From: Jeff Watson
Sent: Tuesday, August 07, 2012 10:16 AM
To: 'Cascade Irrigation District'
Cc: Christine M. Garcia; Chris Cruse (cruseandassoc@kvalley.com)
Subject: RE: BL-12-00017 Armstrong

I have reviewed this application and I notice a change is total acres from 1.60 to 1.67. I would like to know why the BLA creates this change in net acres. Also, as per CID Resolution 01-2006, A \$100.00 Administrative processing fee will be required for final approval on this BLA. All plats, short plats, lot consolidation, boundary line adjustments, etc. require a \$50.00 per lot fee for final approval. The fee is based on how many lots remain after the change.

KNUDSON SHORT PLAT
 PART OF BLOCKS 85, 86, 87 & 88, STATE ADDITION
 LOCATED IN SECTION 36, T. 18 N., R. 18 E., W.M.
 KITTITAS COUNTY, WASHINGTON

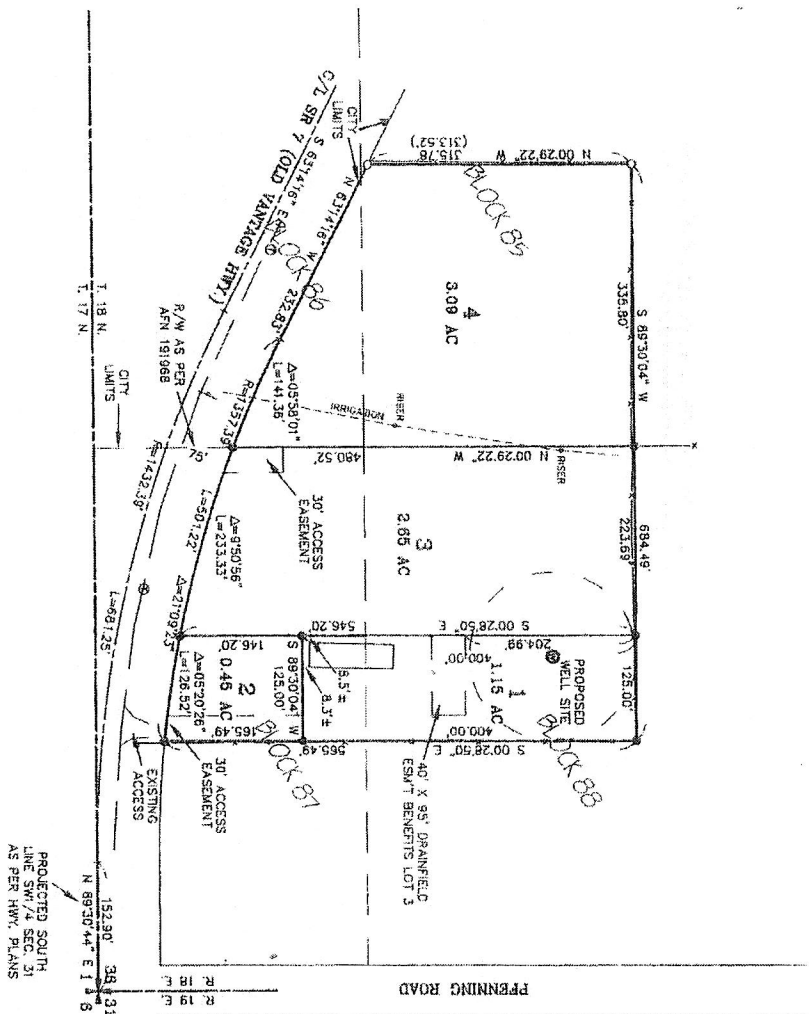
To be honest I am not real clear as to why there is a discrepancy between the acreages listed in the original short plat and the current parcel listings. **Perhaps Mr. Cruse or Ms. Garcia can shed some light on those numbers.** As to the costs and requirements for the proposal, our current practice provide information to the Irrigation Entity and the applicant and to insure that requirements are met. The logistics of that process we leave up to the parties involved. Final approval of the application will not be granted without your consent/approval.
